From: Joanne Lewis
Sent: 12 June 2019 10:00
To: Simon Davis; Planning.Responses
Subject: RE: BN/35/19/DOC Lake Lane External Lighting condition.

Thank you for the additional information submitted, however before I can recommend discharge of the condition I would request that the developer confirm that their proposed scheme conforms with the design guidance in the Institution of Lighting Professionals, Guidance Notes for the Reduction of Obtrusive Light for Zone E2 – Rural.

Pharola DS

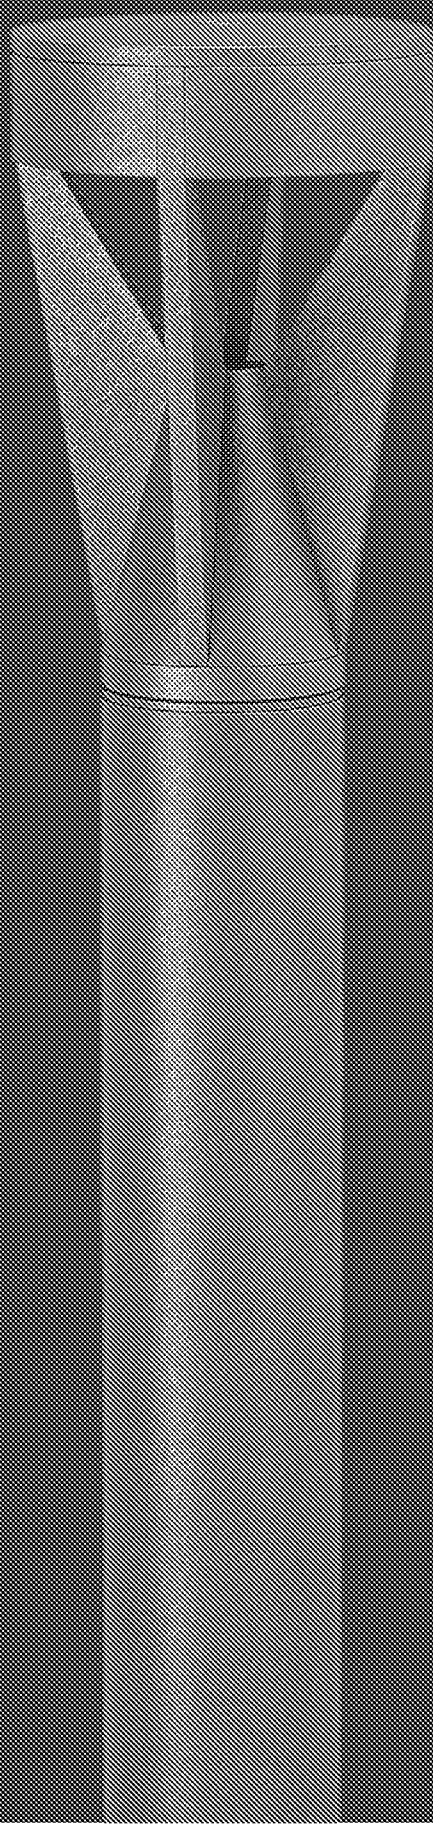
1. Upward Light – 0% Upward Light
2. Light Intrusion with 0 upward light and the bollard at 1m the unit should not produce light intrusion.
3. Luminaire intensity after curfew (Usually 23:00) no greater than 500 I The Pharola produces 535, would suggest the bollards are switched off after 23:00

Please see attached response from Environmental Health. Can you provide on illumination levels and light spillage from the proposed lighting and justification as to why downward facing light sources are not being used.

If the applicant confirms that the lights will be switched off between 23.00 hours and 05.30 hours (when necessary in the darker months) in line with West Sussex Street Lighting, this will be acceptable to discharge the condition.

The 'Pharola' bollard selected does not emit 'upward' light but does illuminate sideways, in keeping with its purpose to illuminate specific areas of the private access road there by allowing safer passage for the residents during darkness.
